## KITTITAS COUNTY COMMUNITY DEVELOPMENT SERVICES

### RE: Mason Parcel Combination (CB-25-00004) – Conditional Preliminary Approval

Parcel#548135          Parcel# 538135

Site Plan

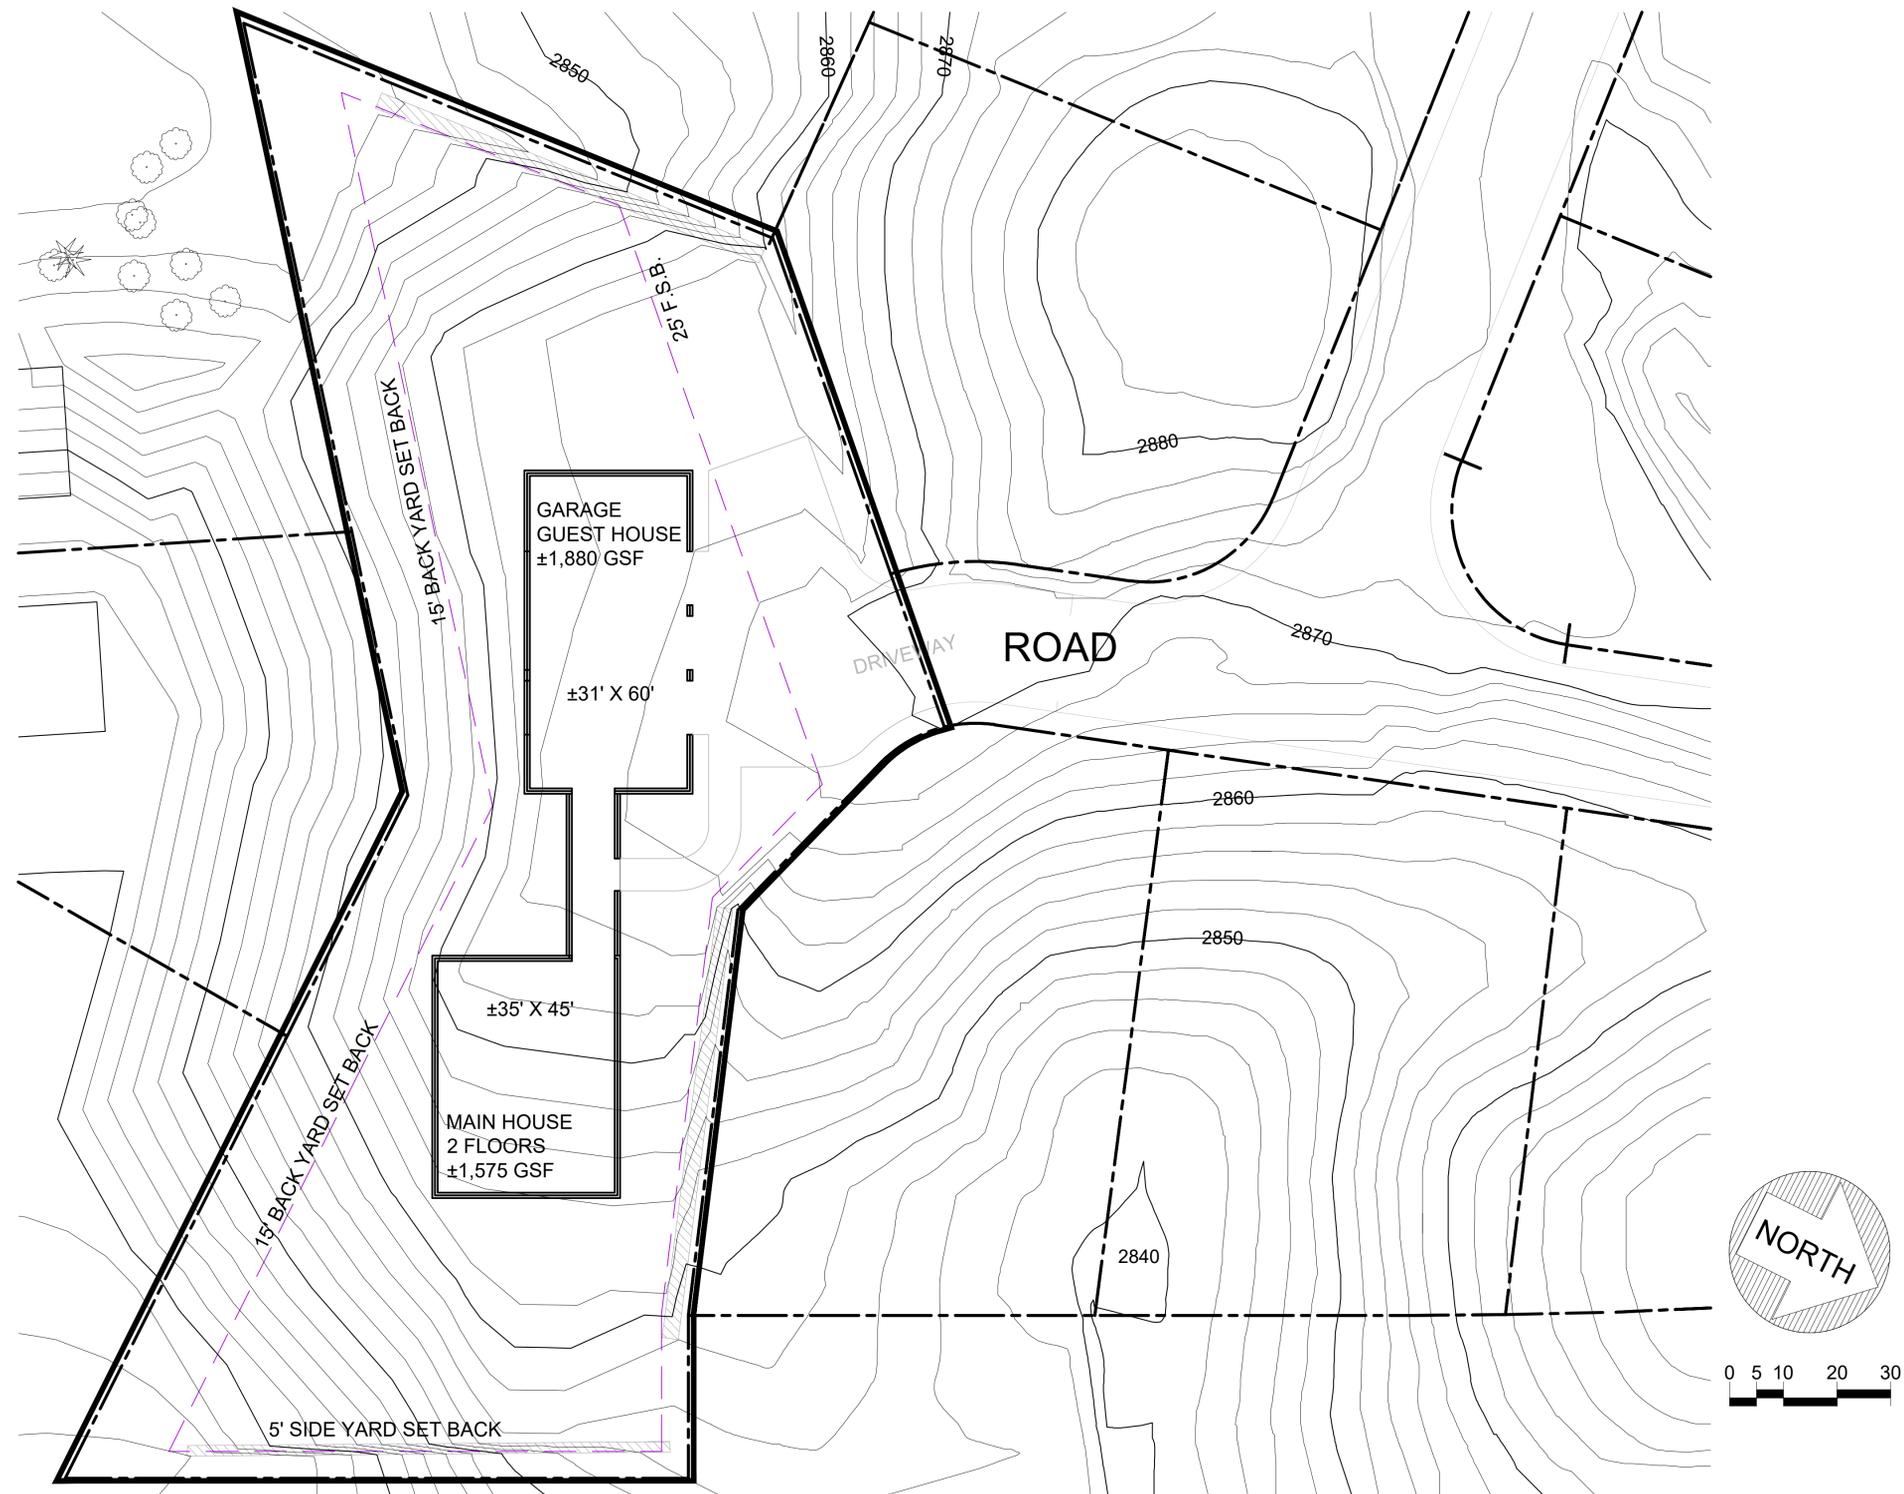
1. Provide documentation addressing Survey Comment: *“Per the original plat of Ski Acres Estates, there is a 10’ wide drainage easement through Lot 23. Please provide evidence that this was vacated, or show its location in relation to the proposed building, to show that it falls outside building envelope.”*
2. Kittitas County Public Works comments are attached for your review.
